Code Enforcement Comments

PR-2022-006627

PS-2024-00060 – SKETCH PLAT

Project Name: 335 Woodward Rd SE / Mario's Catering

PLAT OF
LOTS 1 THRU 4
MARIOS CATERING

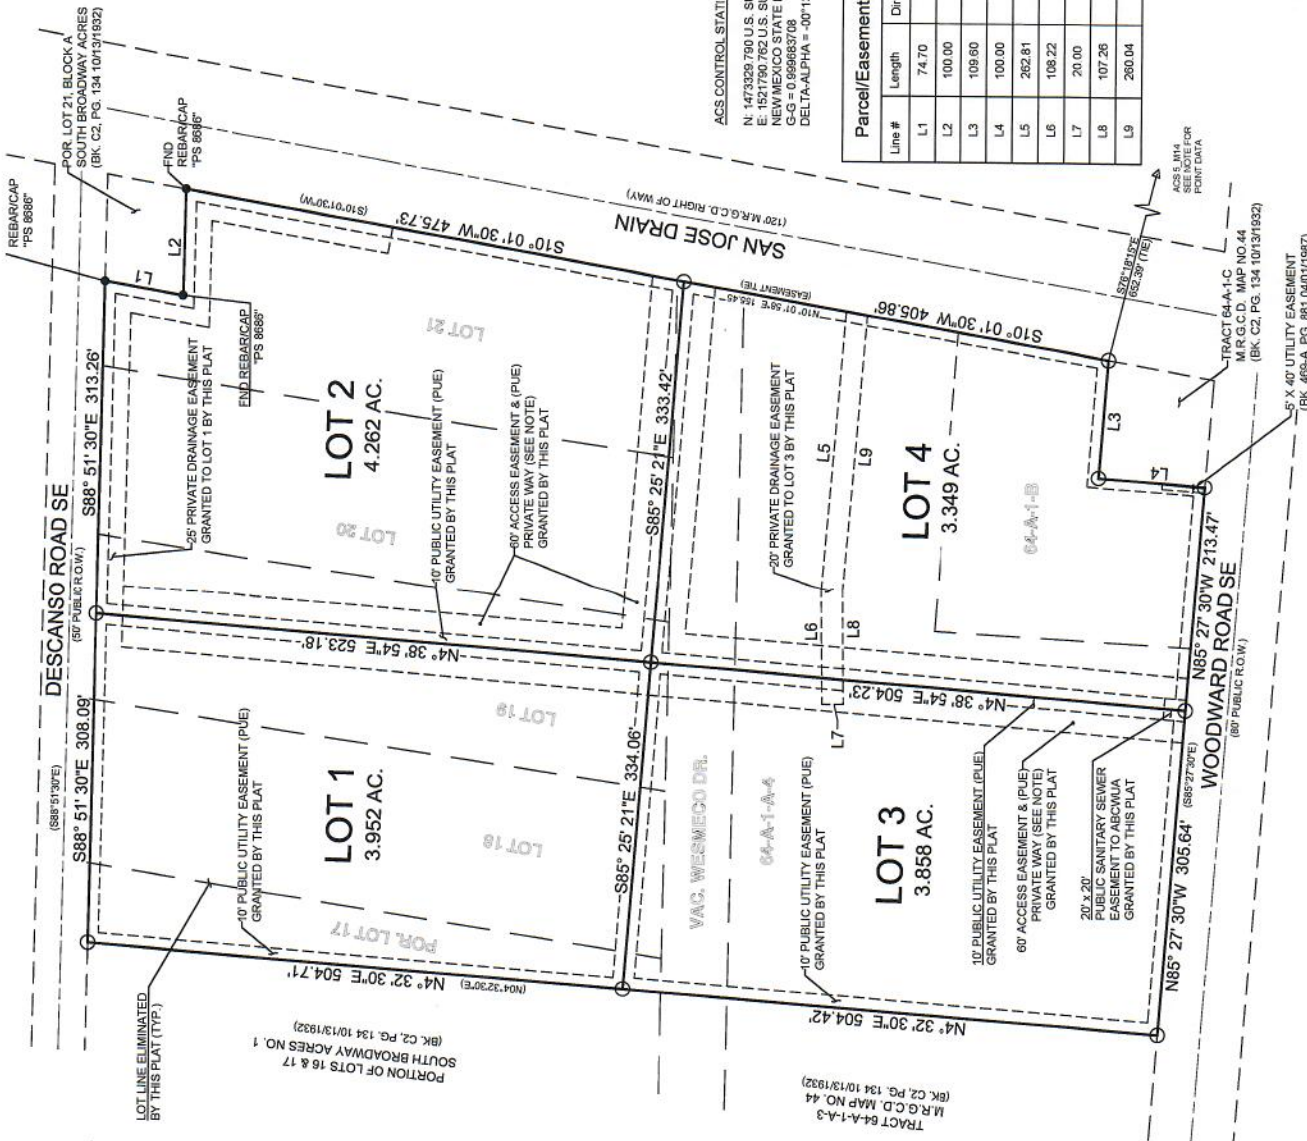
- Hydrology has an approved Conceptual Grading & Drainage Plan (M14D066) with engineer's stamp 05/08/2023.
- Add a Blanket Cross Lot Drainage Easement note specifying the beneficiary and maintenance agreement.
- Comment – Prior to submitting for Building Permit, a licensed New Mexico civil engineer will need to submit a Grading & Drainage Plan to Hydrology for review & approval if one of these conditions is met. (500 cy of grading, 1,000 sf of proposed building, or 10,000 sf of proposed paving).

1. Woodward is a Major Collector and requires 6' sidewalk with 5' to 6' landscape buffer. Descanso is a local road and requires 5' sidewalk with a 4' to 6' landscape buffer. Please provide a diagram listing the sidewalk and buffer width on both roadways. All work done in the ROW will need to be placed on an infrastructure list.
2. For Descanso Road, a turn-around is required within the property because the road is over 150 feet long. Provide right-of-way and/or easement and pavement for the turnaround. See some examples of turnarounds below.

- Please clarify the intended action for the vacation of Wesmeco Rd. Do you intend to vacate and pave this road? That answer could determine if the plat action would be minor or major.
- Demonstrate compliance with section 7 of the DPM Table 7.2.29 and Required Improvements section from 5-4(N) of the IDO. In regards to the Sidewalk width requirements and the accompanying landscape buffer. This matter may have been established by previous infrastructure list.

- The application numbers must be added to the Plat. Final platting documents must be sealed and signed by a design professional licensed in the State of New Mexico.

A1.1

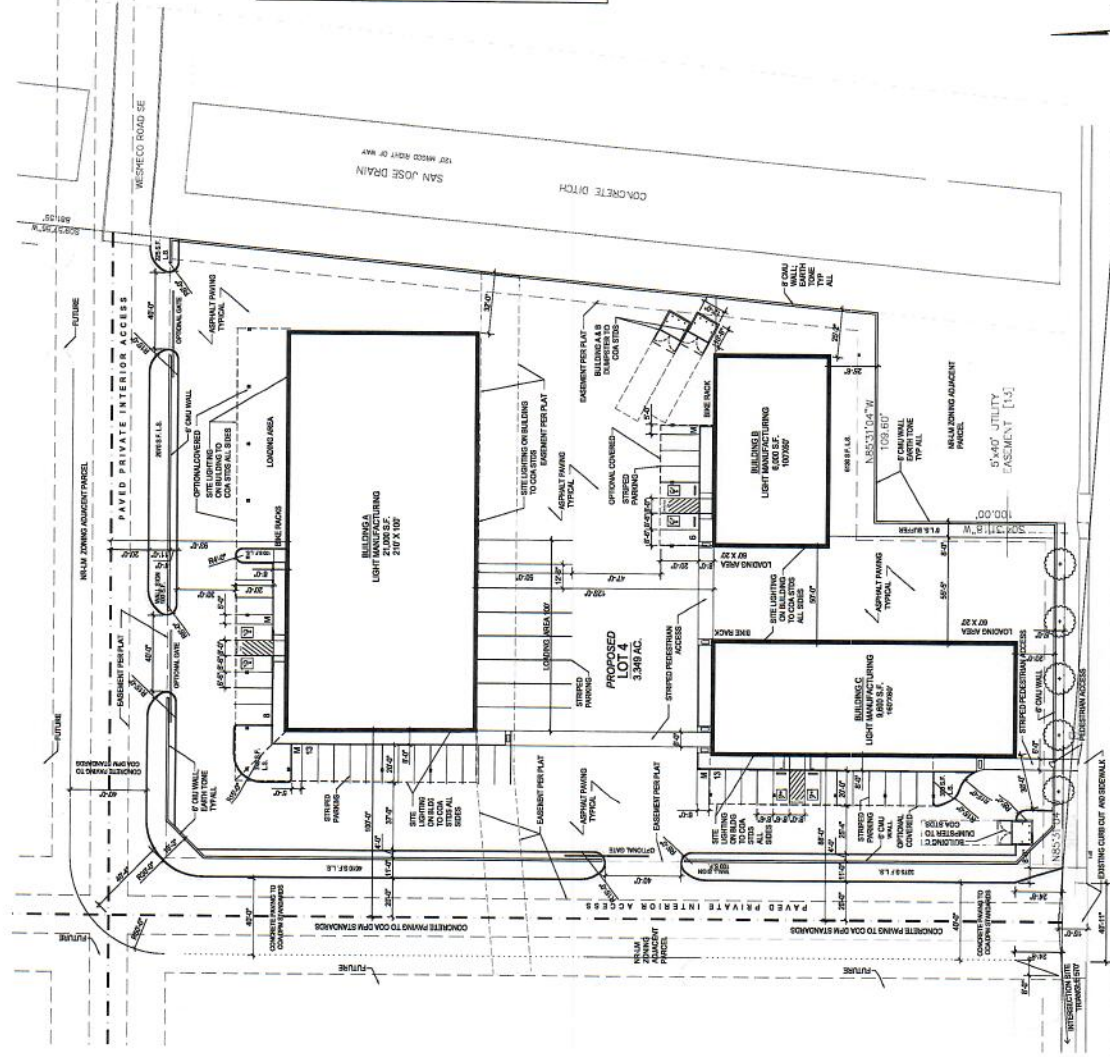
1. The property is located with the Railroad and Spur Area, and the development plan described for Mario's Catering would include uses such as vehicle repair, cold storage warehouse, and outdoor storage of vehicles and/or equipment, each of which would trigger a Cumulative Impacts Analysis and approval by EPC, as per IDO 5-2(E)(1).
2. An EPC approved Site Plan must be obtained prior to replat, as per IDO 5-2(E)(2)(e).
3. See comments from prior Sketch Plat included in notes provided regarding Future Development, as well.
4. CE has no further comments at this time.

Note: Any future development on proposed lots that have frontage along Woodward Rd SE, which meets the applicability in IDO Subsection 14-16-5-6(B) will require a landscaping plan that includes Street Frontage trees as specified in 5-6(D).

- Site is within Cumulative Impacts Area. Per 5-2(E)(1)(c) confirm the proposed uses for this subject property. If the use is in the list of uses, then the site plan must be approved by the Environmental Planning Commission. Catering food with cold storage would not trigger cumulative impact review.
- Airport Protection Overlay standards (including 3-3(D) DEVELOPMENT STANDARDS) may apply to this project.
- For future development a sensitive lands analysis report is required. Also please refer to 5-2(F) DRAINAGE AREAS
